KITTITAS COUNTY DEPARTMENT OF PUBLIC WORKS

MEMORANDUM

TO: Community Development Services
FROM: Joy Potter, Engineering Manager
THRU: Paul D. Bennett, P.E., Director of Public Works
DATE: March 31, 2005
SUBJECT: Game Farm Cluster Subdivision

Our department has reviewed the Cluster Subdivision application and has the following comments:

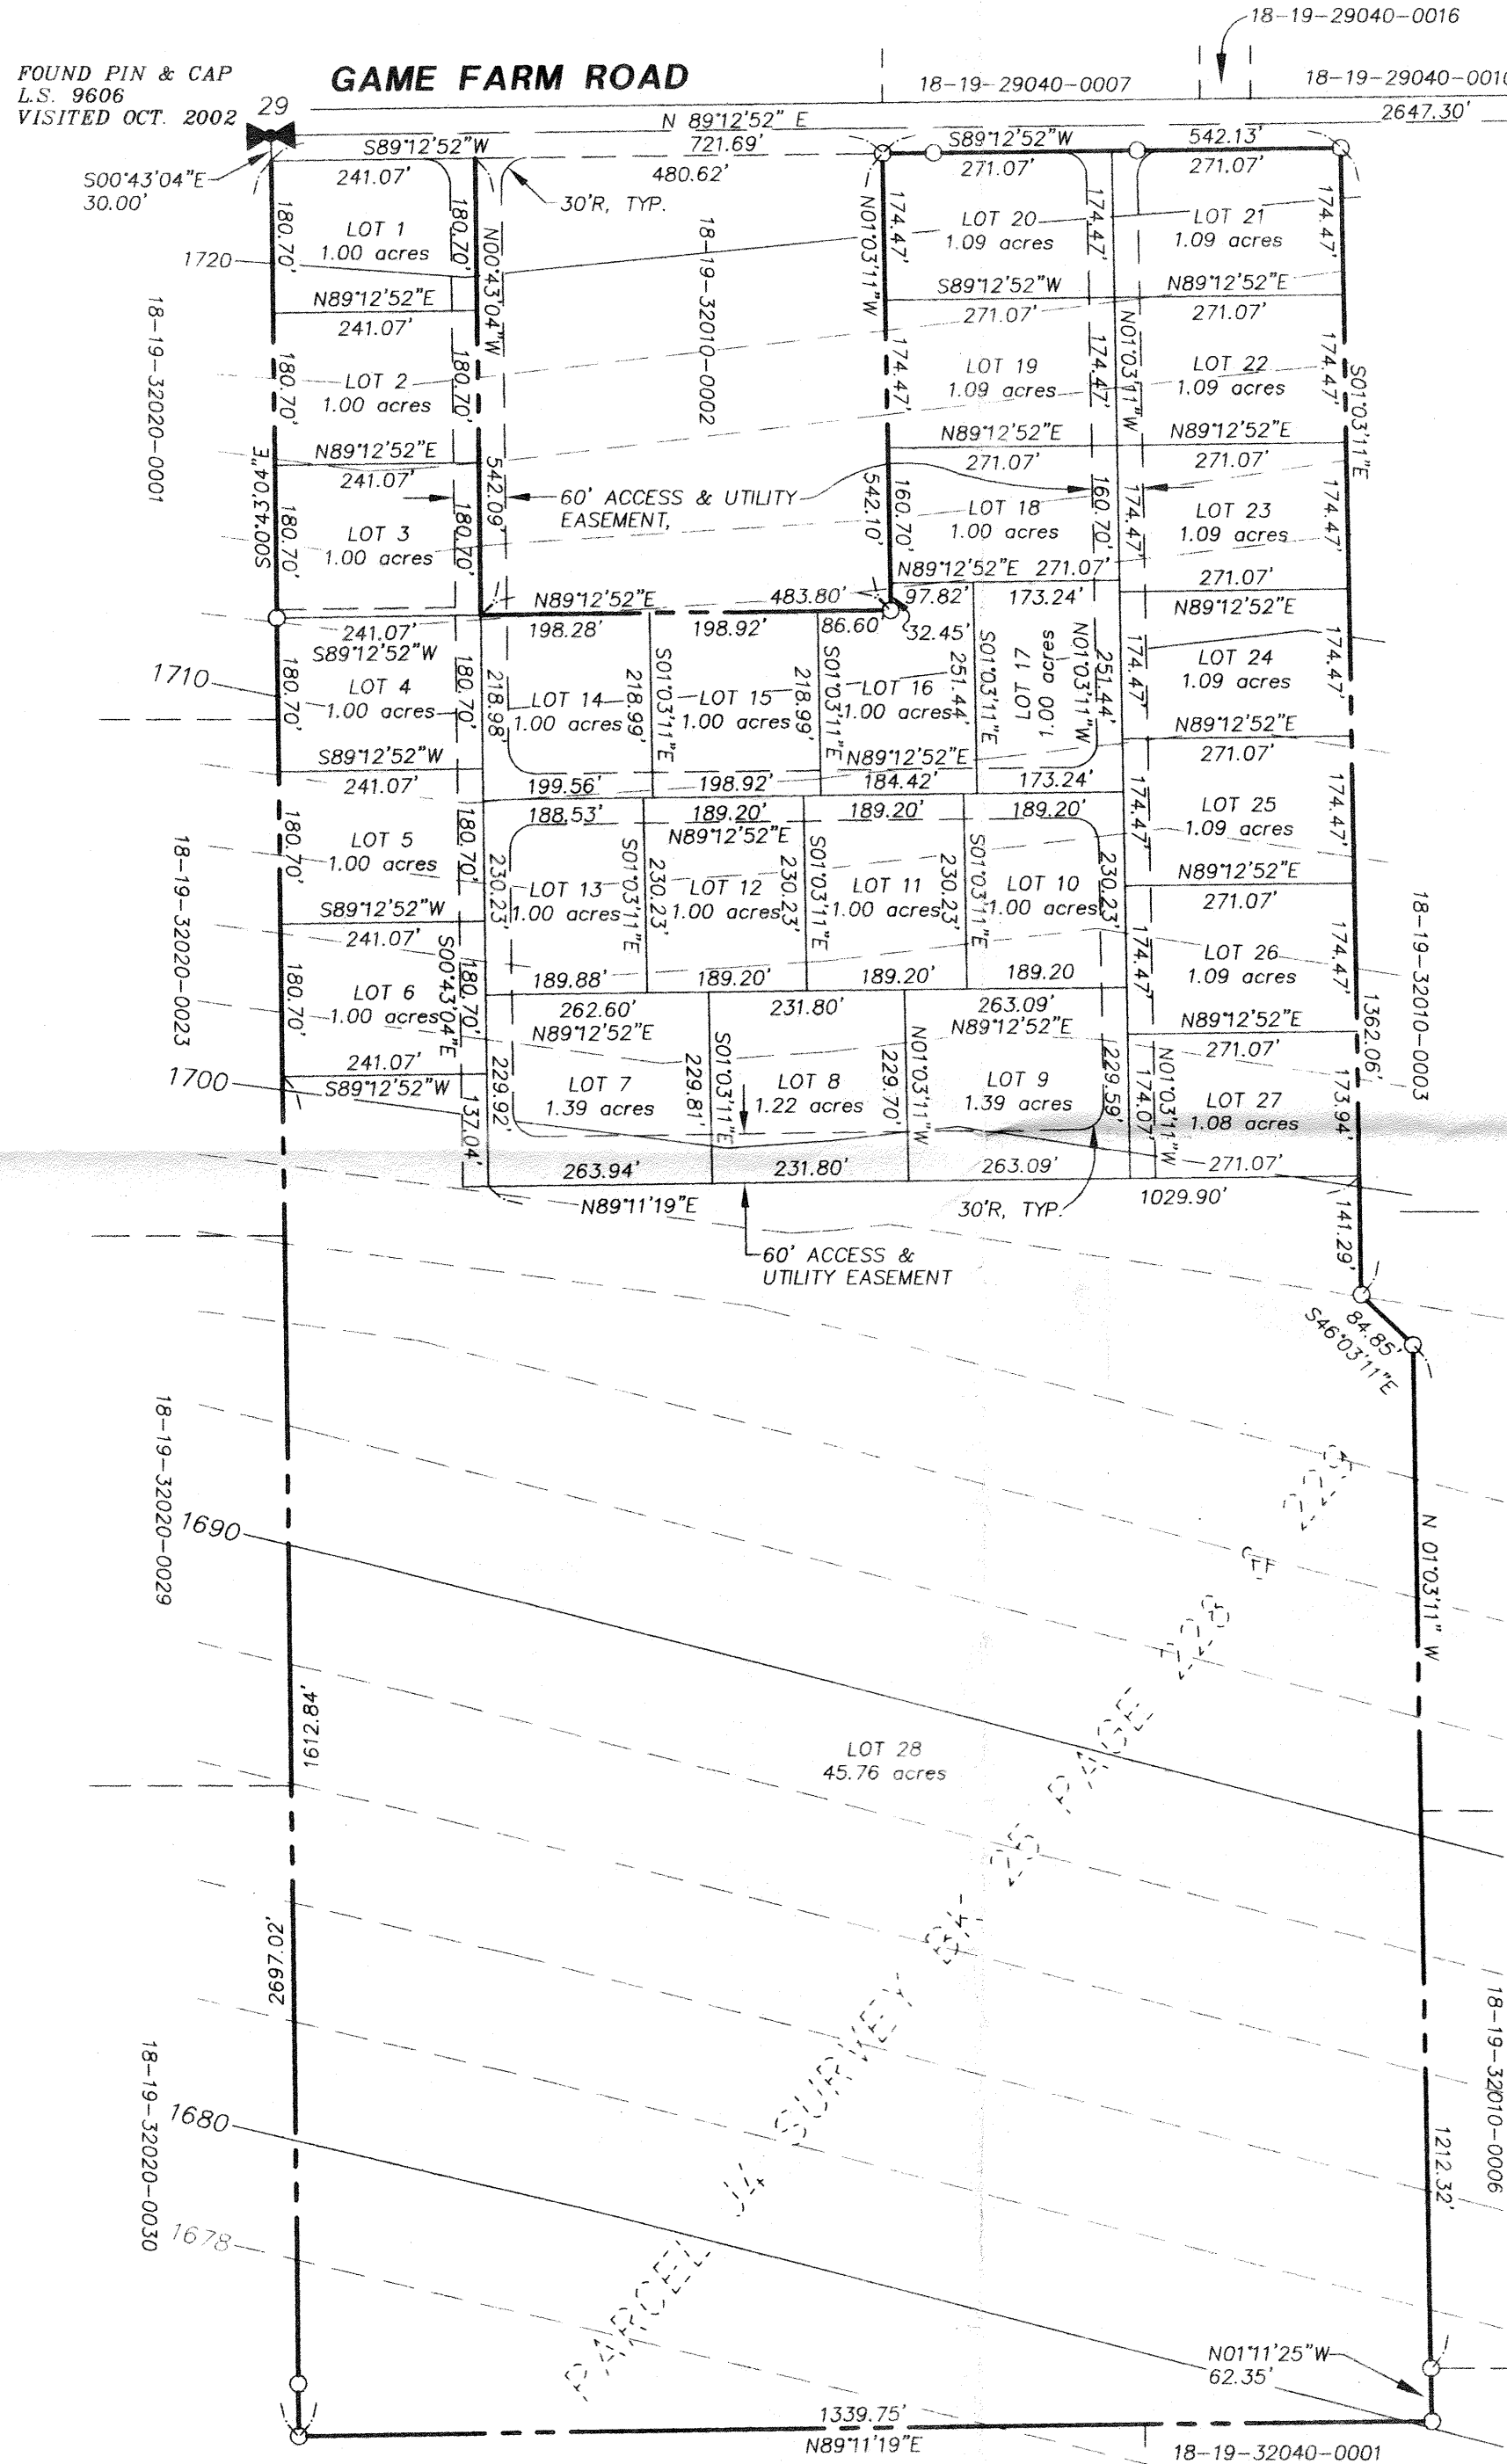
1. Private Road Improvements: Access shall be constructed as a High-Density Private Road and serve no more than 40 tax parcels. (See current Kittitas County Road Standards)

- a. Access Easements shall be improved to a minimum of 60'. The roadway width shall be 22', with 1' shoulders = 24' total width.
 - b. All easements shall provide for AASHTO radius at the intersection with a County Road.

- c. Minimum centerline radius will be 60'.
 - d. Surface requirement BST/ACP.
 - e. Maximum Grade 8% flat, 12% rolling or mountainous.
 - f. Stopping Site Distance, reference AASHTO.

- g. Entering Site Distance, reference AASHTO.
 - h. Maintenance of driveway approaches shall be the responsibility of the owner whose property they serve. The County will not maintain accesses.

2. **Road Frontage:** In accordance with Kittitas County Road Standards 12.01.090(B), road frontage improvements will include removal of irrigation water from the road right of way to be relocated in the 10' utility easement. The shoulders shall be improved to 4:1 slopes.

5. **Access:** Access to Lots 1, 20, and 21 will be restricted to the private easements only. No access will be allowed from Game Farm Road. The current access for the single family dwelling will be grandfathered and will not be required to relocate for this project. However, any future development of the parcel 18-19-32010-0002 access will be restricted to the new internal road system. No access will be allowed from Game Farm Road.

- a. All Parcels and/or future created parcels within this Cluster Plat shall be limited to the private access easement shown on the face of this Cluster Plat, no direct access will be granted off of Game Farm Road. **Plat Note.**

- b. Access to Lots 1, 20, and 21 will be restricted to the private easements only. No access will be allowed from Game Farm Road. **Plat Note**
